KIRKLEES METROPOLITAN COUNCIL INVESTMENT & REGENERATION SERVICE

DELEGATED DECISION TO DETERMINE APPLICATIONS FOR CONSENT, AGREEMENT OR APPROVAL REQUIRED BY CONDITION

Reference No:	2026/44/92259/W
Site Address:	Land at, Yew Tree Road, Birchencliffe, Huddersfield, HD2 2EQ
Description:	Discharge of details reserved by condition 10 (crime prevention measures) on previous permission 2021/94363 for reserved matters application pursuant to outline permission 2018/90151 for erection of 17 dwellings
Recommending Officer:	William Simcock

Drawing Title **Planning Layout**

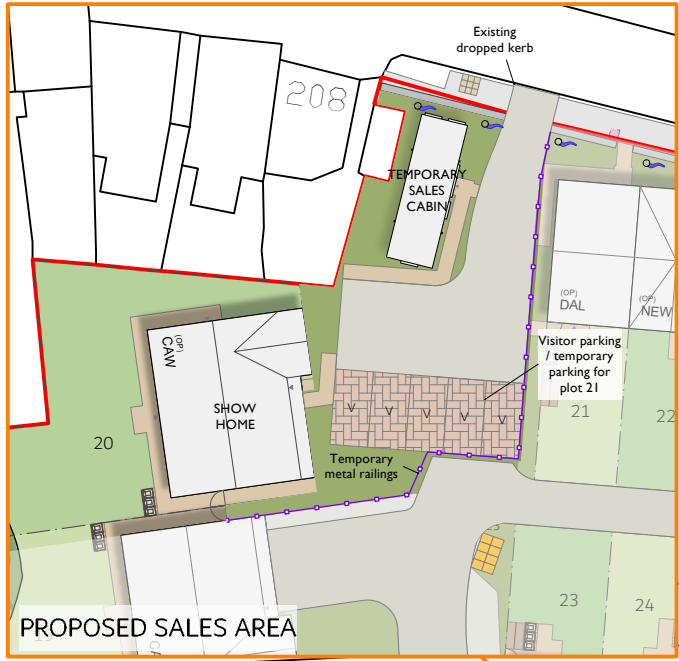
- PAS 24:2016 is somewhat obsolete now. Could the window and door standard be upgraded to PAS24:2022 if at all possible?
- The shed for cycle / motorcycle storage should be securely fixed to a suitable substrate foundation. Hinges should be reinforced with coach bolts. Storage devices/ ground anchors inside should be security rated to at least Sold Secure SS104 Bronze, STS 225 Issue 2 Burglar Resistance BR1(S), STS 205 Issue 8 Burglar Resistance BR1, LPS 1175 Issue 8 Security Rating A1, STS 501 Security Rating TR1 or STS 503 Security Rating TR1. Will the applicant meet some or all of these requirements?
- Will intruder alarms be provided in all dwellings as standard? If so, they should meet the requirements of BS EN 50131 (wired and wire free

- Are there any plans for CCTV provision onsite?

- i. the shed will be fixed to a concrete base and secured with coach bolts;
- ii. Intruder alarms will not be provided as standard and there are no plans for CCTV provision on site.

In addition, at the request of the case officer, a combined site plan (both phases of the development, totalling 27 dwellings) and key were supplied (24/09/2026) showing the location of cycle sheds within the plots. All plots except 13 and 17-20 (which are to have integral garages) are to be provided with external cycle sheds. For those that lack cycle sheds, officers consider that storage within the garage is an acceptable alternative.
